Engineers Comments Regarding Surface Water Drainage

Application Reference:	WA/109/24/OUT	Reviewer Reference:	ADC/PC
Planning Officer:	Harry Chalk	Date of Review:	06/06/2025
Site Name:	Sussex Business Village Lake Lane Barnham PO22 0AL		
Application Description:	Outline planning permission for 3 No. attached dwellings with associated gardens, access and parking. This application is in CIL zone 3 (CIL liable as new dwellings) and is a dual parish application with Yapton Parish Council.		
Assessment Number:	1 of 1

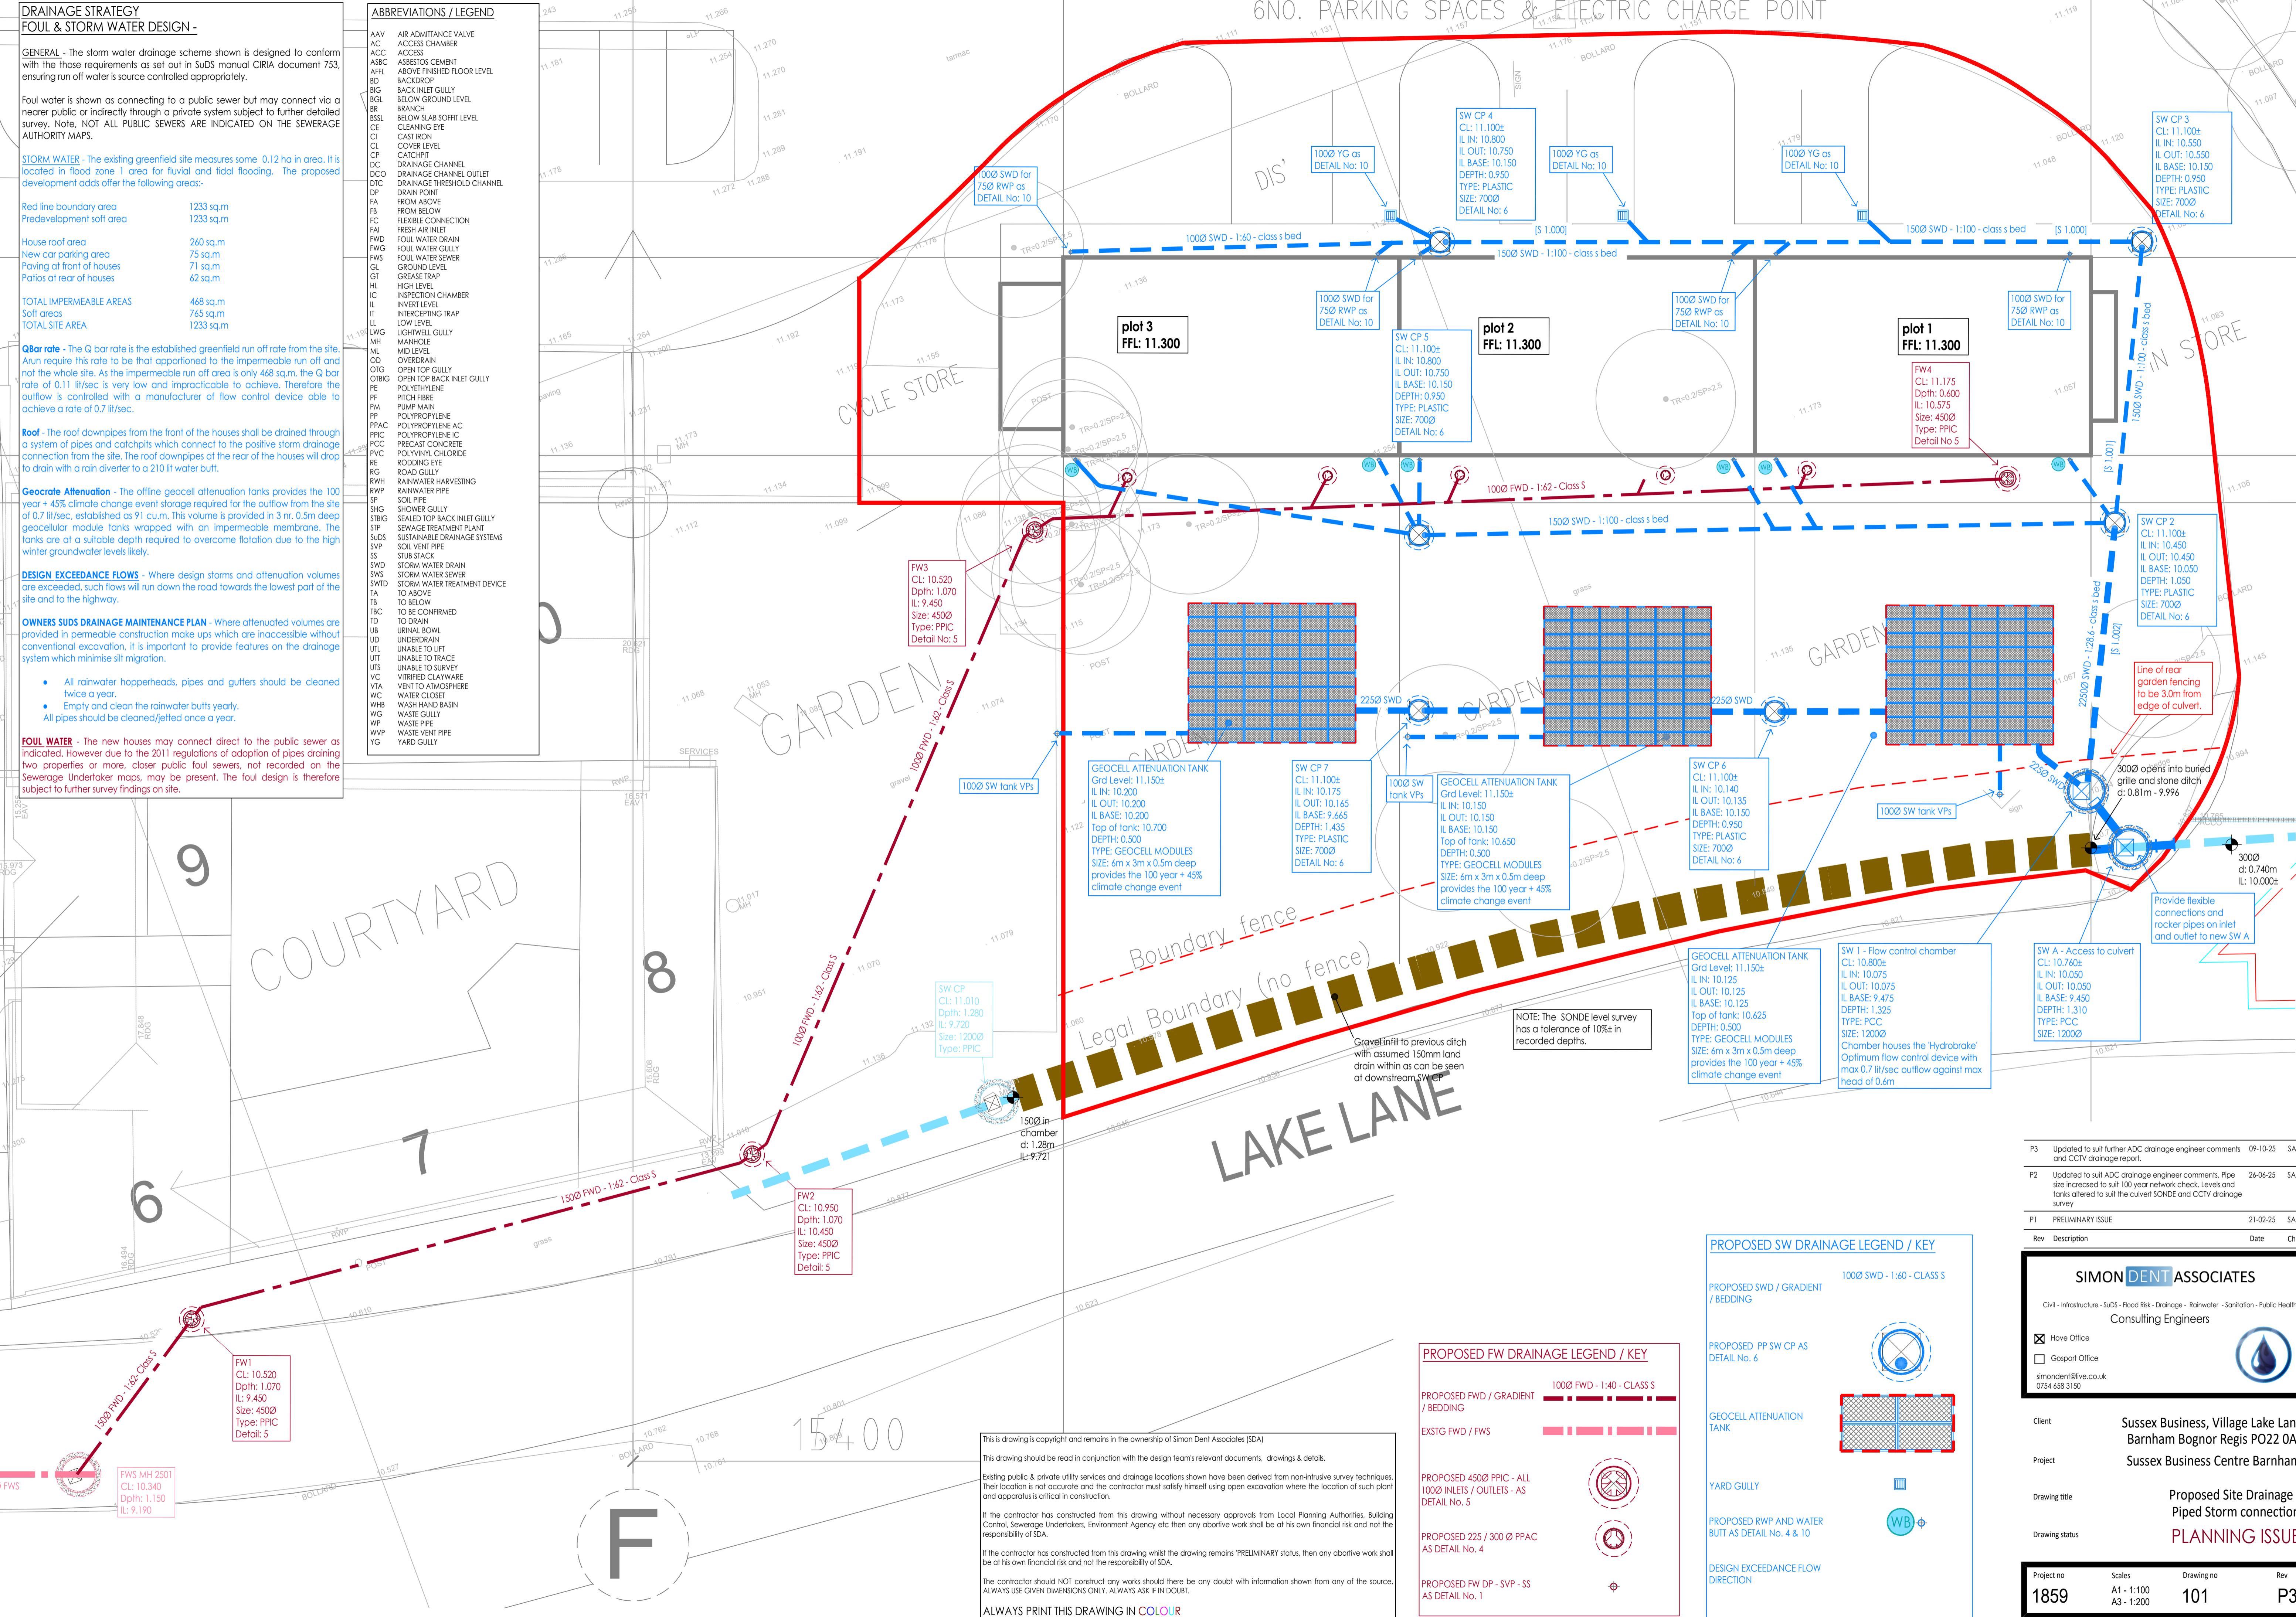
The drainage strategy comprises two options, 1) Infiltration into the ground 2) Discharge to existing culverted watercourse.

Option 1 has been based upon insufficient groundwater monitoring and infiltration testing. This fact is recognised by the applicants designer. Winter groundwater monitoring is required and this will determine if winter infiltration testing is viable, as one metre freeboard needs to be achieved between the base of infiltration structures and peak groundwater levels.

Groundwater monitoring and infiltration testing **must** be undertaken at the location of the infiltration structures. This has not been achieved with the monitoring and testing undertaken to date. Infiltration into made ground should not be considered due to its variability.

Option 2 consider a discharge to an adjacent culverted watercourse, on the assumption that infiltration proves unviable. Full details of the culvert have not been provided ie. condition and levels, etc. Therefore, it is not possible to confirm for sure if a gravity connection is possible or if the culvert is fit for purpose. It should be noted that Land Drainage Consent would also be required for such a connection.

The applicant should incorporate permeable paving and rain gardens with any future proposal. This will help achieve the required water treatment requirements, and the preference for open features (ie. rain gardens). Only option 1 considered such measures but option 2 didn't.

Any storage structures should not span more than one property boundary.

All structures must achieve a minimum distance of 3 metres from the edge of the culverted watercourse. This includes boundary fencing. A plan clearly showing this arrangement will need to be submitted.

1. Existing culverted watercourse to be further investigated in terms of condition and levels. Provide evidence that a gravity connection to the culvert can be achieved, this must include detailed levels information with the outlet to the culvert achieving a soffit to soffit connection, and the design adjusted as necessary, with full hydraulic modelling for the onsite system. The culvert must also be fit for purpose, thus a CCTV survey will be required. Any necessary remedial works will need to be detailed and agreed.
2. A plan showing that a minimum 3m distance is achieved between the edge of the existing culvert and any structure/boundary fencing. Culvert to be accurately located.
